Matter raised during the Open Floor Hearing (OFH1 – 30th September 2022) by Boreham Parish Council (Cllr Linda Reed) relating to the increased levels of traffic on the 2 country lanes which are the only access routes to the proposed entrance of the Longfield Solar Farm.

Figure 1. Location and proposed land take

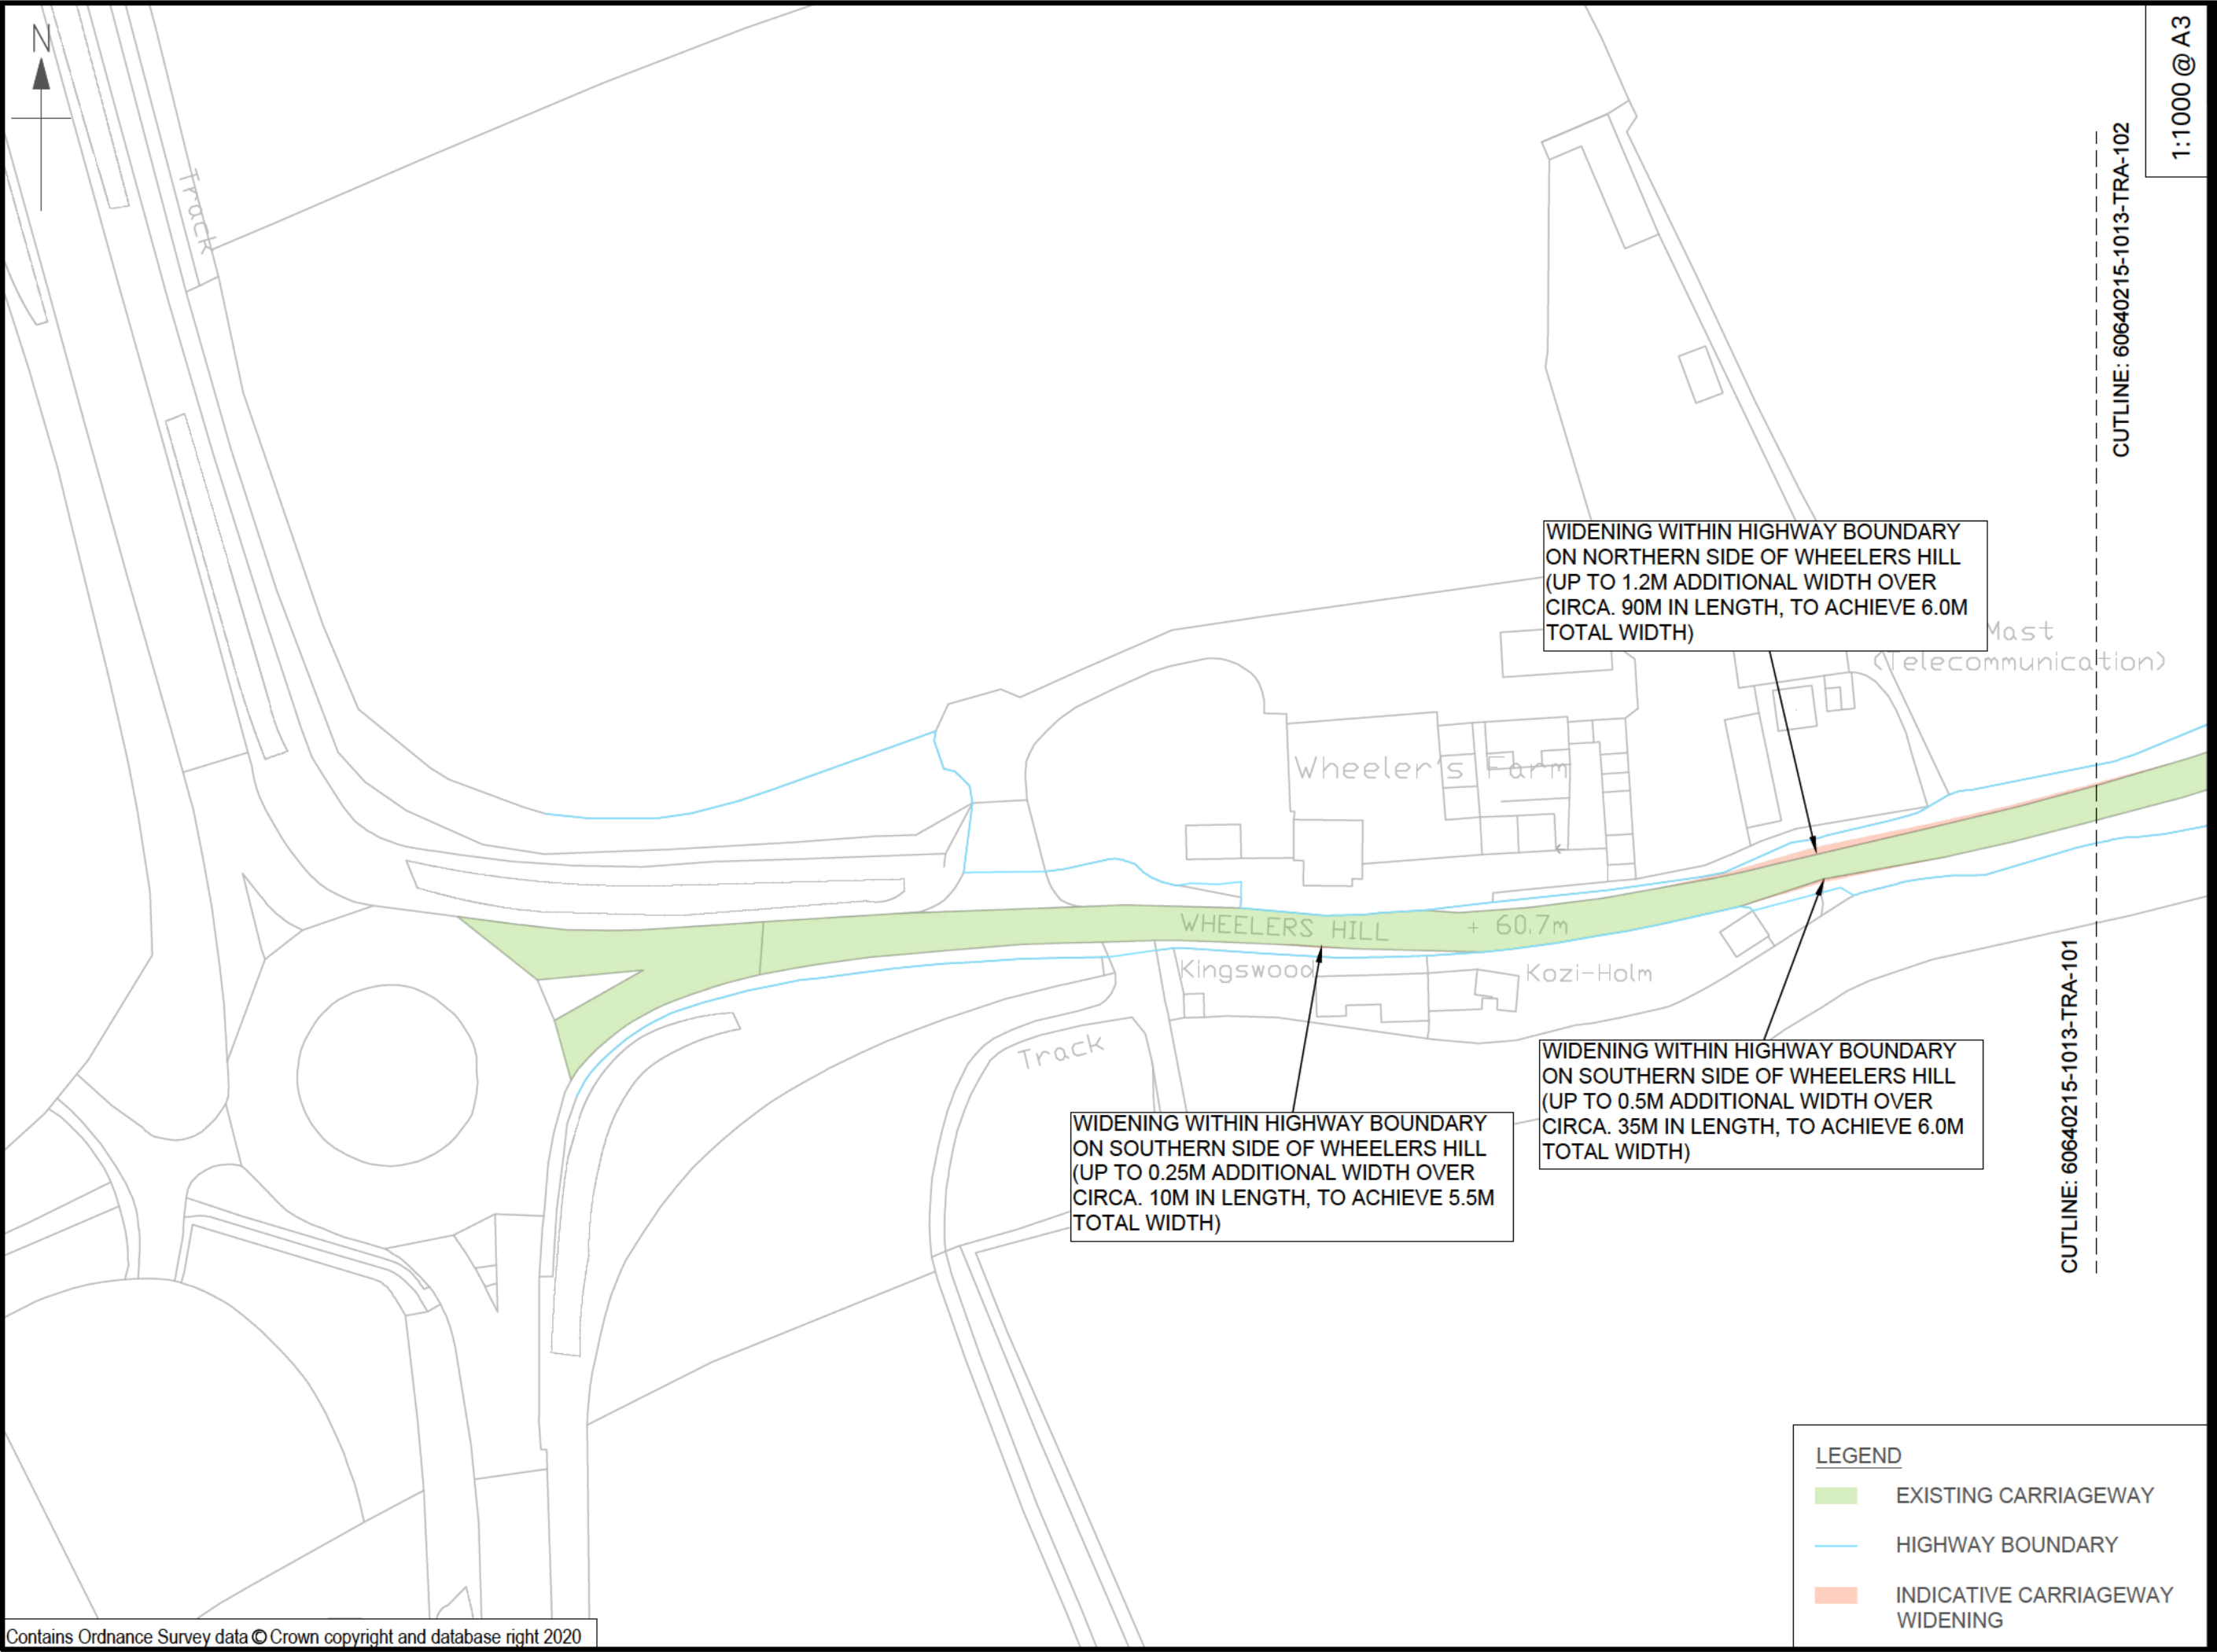
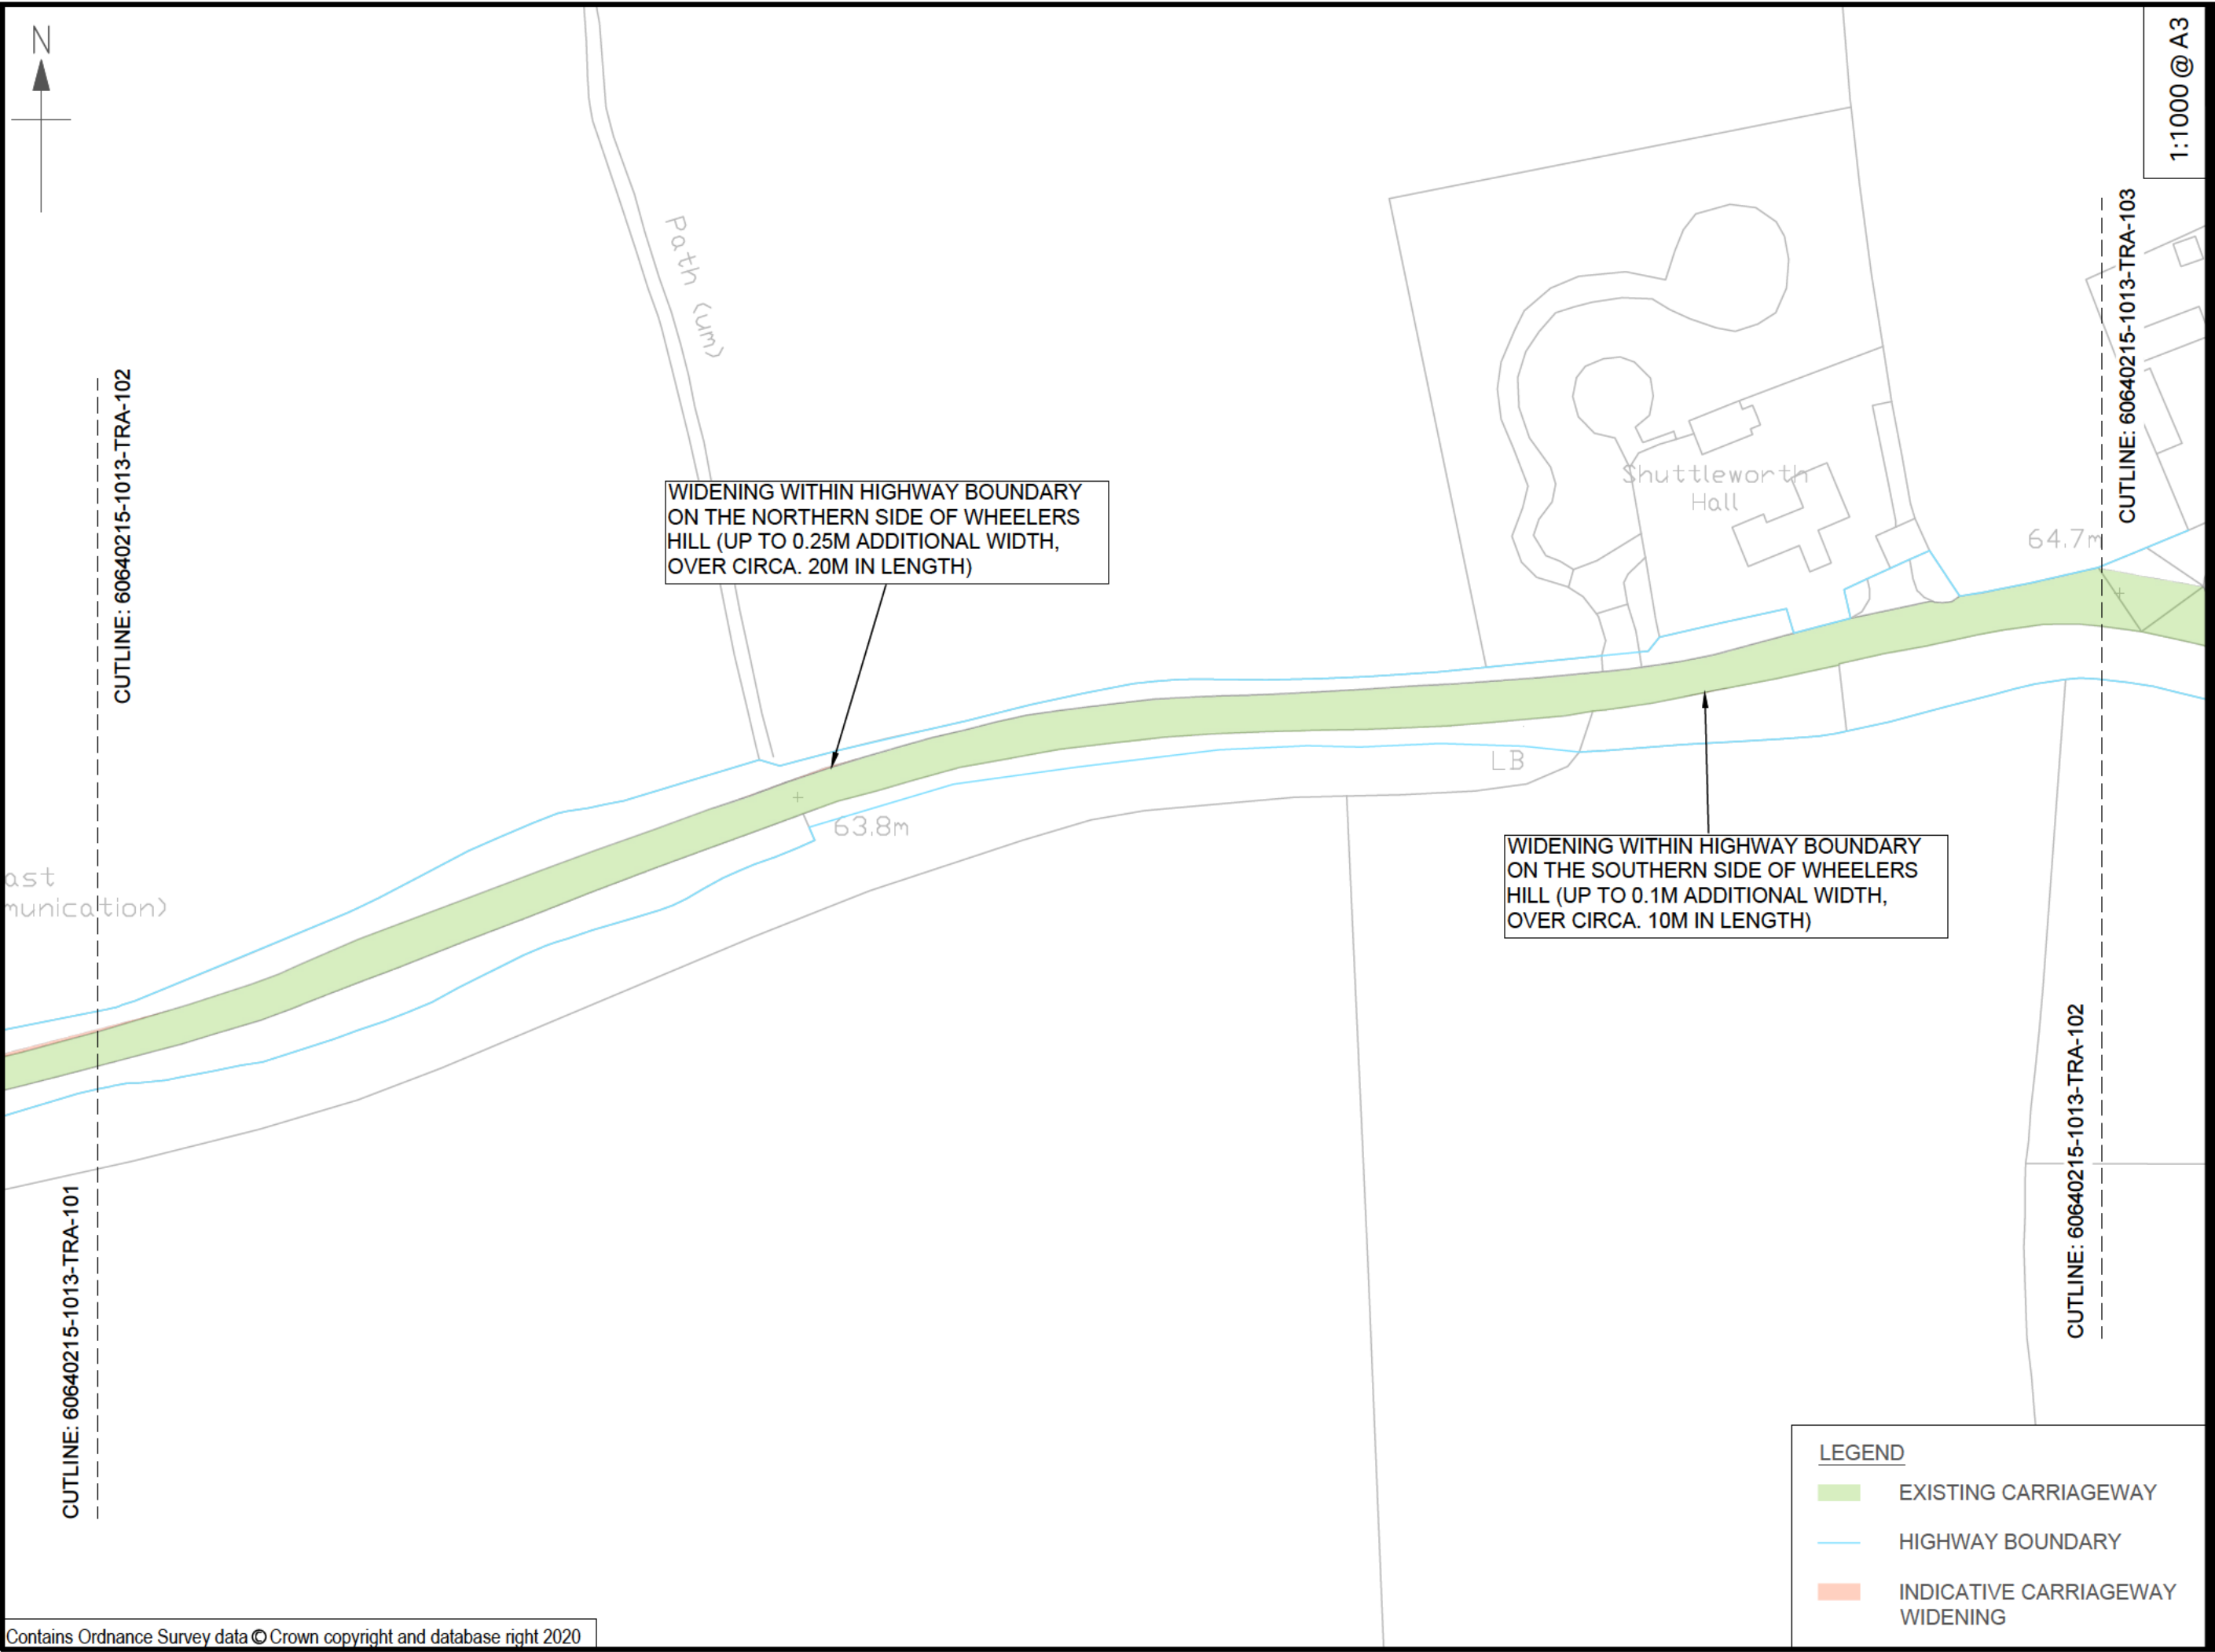
The developer's preferred route to the Longfield site is via Cranham Road and Wheelers Hill. This is country lane which, even following the proposed widening is not deemed suitable for the type traffic anticipated during the implementation phase at Longfield. This route will also be impacted by the construction of the Chelmsford North East Bypass (CNEB). The only other route to the site is via Main Road, Boreham and Waltham Road. It is the stated intention of the developer not to use this route. However, it is likely that there will be times throughout the implementation phase and beyond where this will be necessary due to blockage, delay or temporary closure affecting the preferred route or other routes leading to it. These incidents do occur from time to time.
